An
Coimisiún
Pleanála

Inspector's Report ACP-324191-26

1. Whether the repairs and alterations carried out to the 2 storage warehouse buildings, a workshop and the office/reception building and the resurfacing of the original service yard is or is not development or exempted development;
2. Whether the reoccupation and continued use of the warehouse buildings and the service yards referred to in no.1, for warehousing and associated use, involved development and is or is not development and is or is not exempted development.

Newrath, County Kilkenny.

Fig: Shaded blue highlighting demolitions of tower, part of building and of lean to

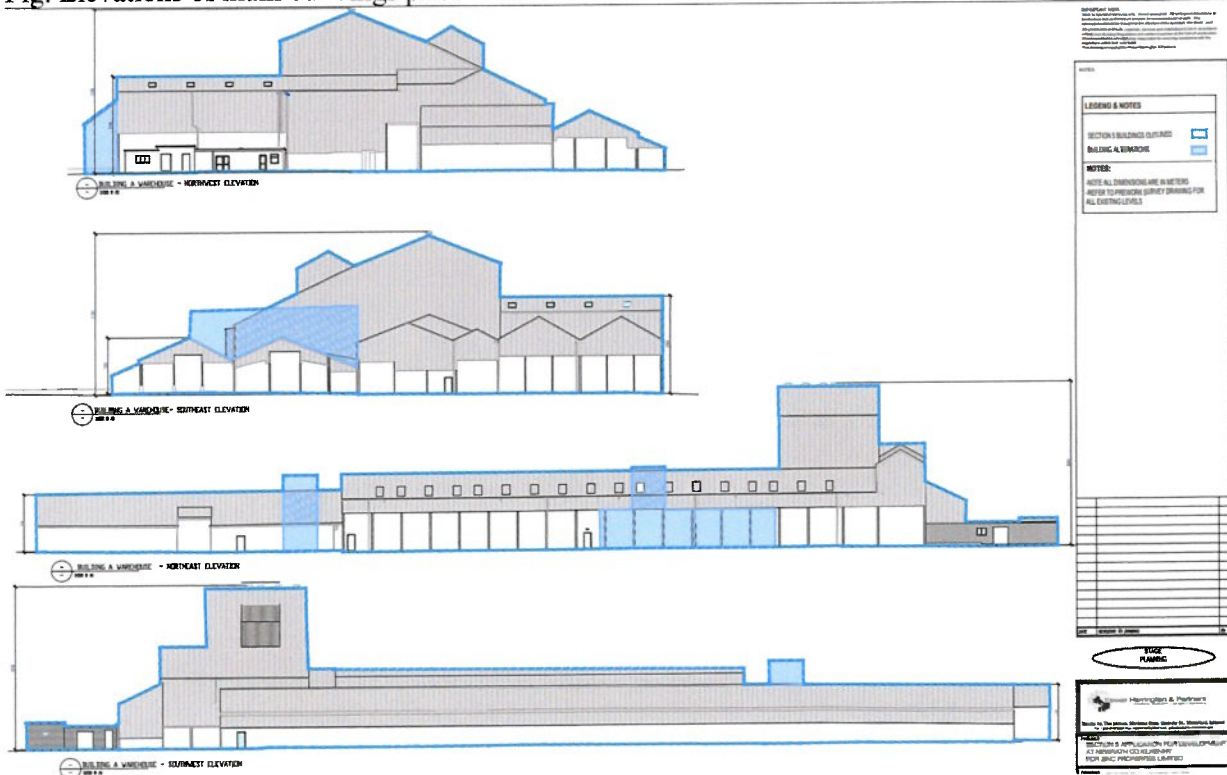
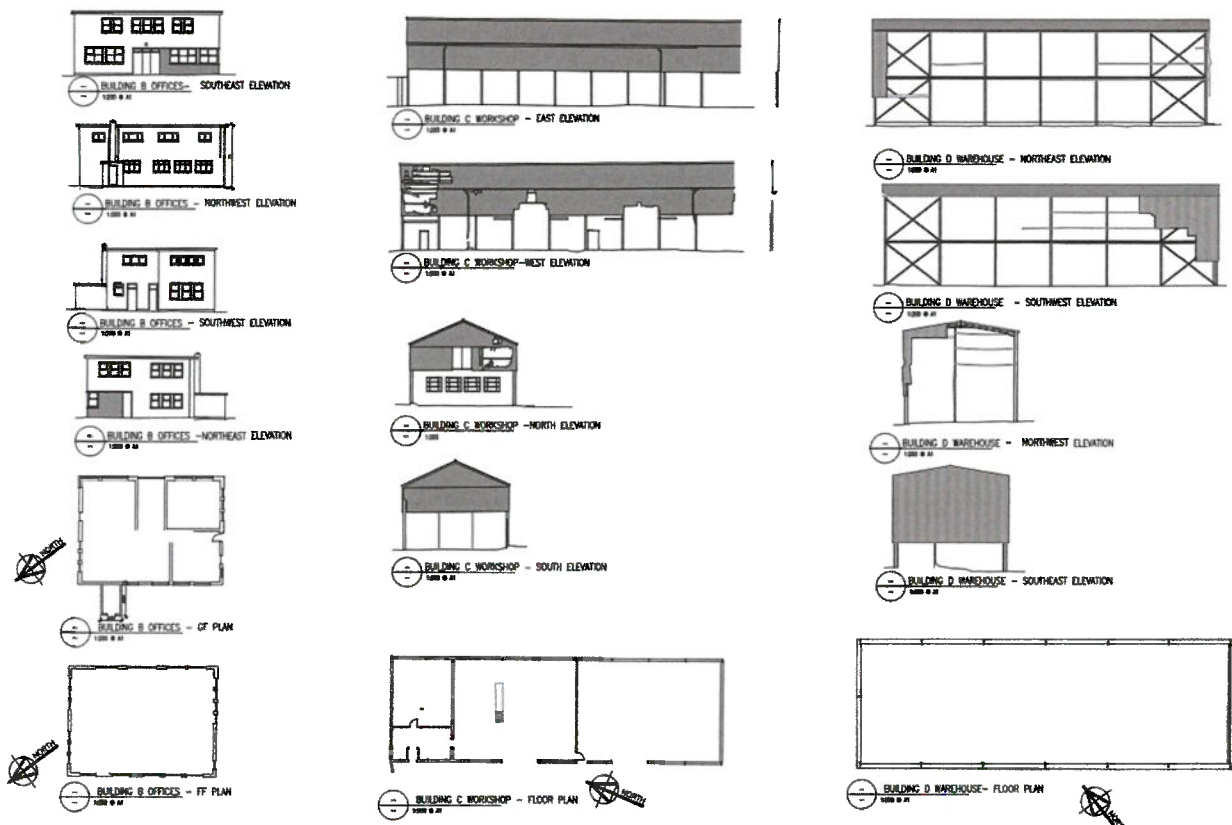
Demolitions: Removal of the projection above roof level and lean-to (Building A), not required for warehouse use, would not materially affect its external appearance rendering it inconsistent with the character of the structure or other structures on the site. The demolitions do not therefore constitute exempted development.

- A typo is acknowledged in the original Planners report under “Demolitions”, which should have concluded that demolitions of lean-to and projection above the roofline, do constitute exempted development.
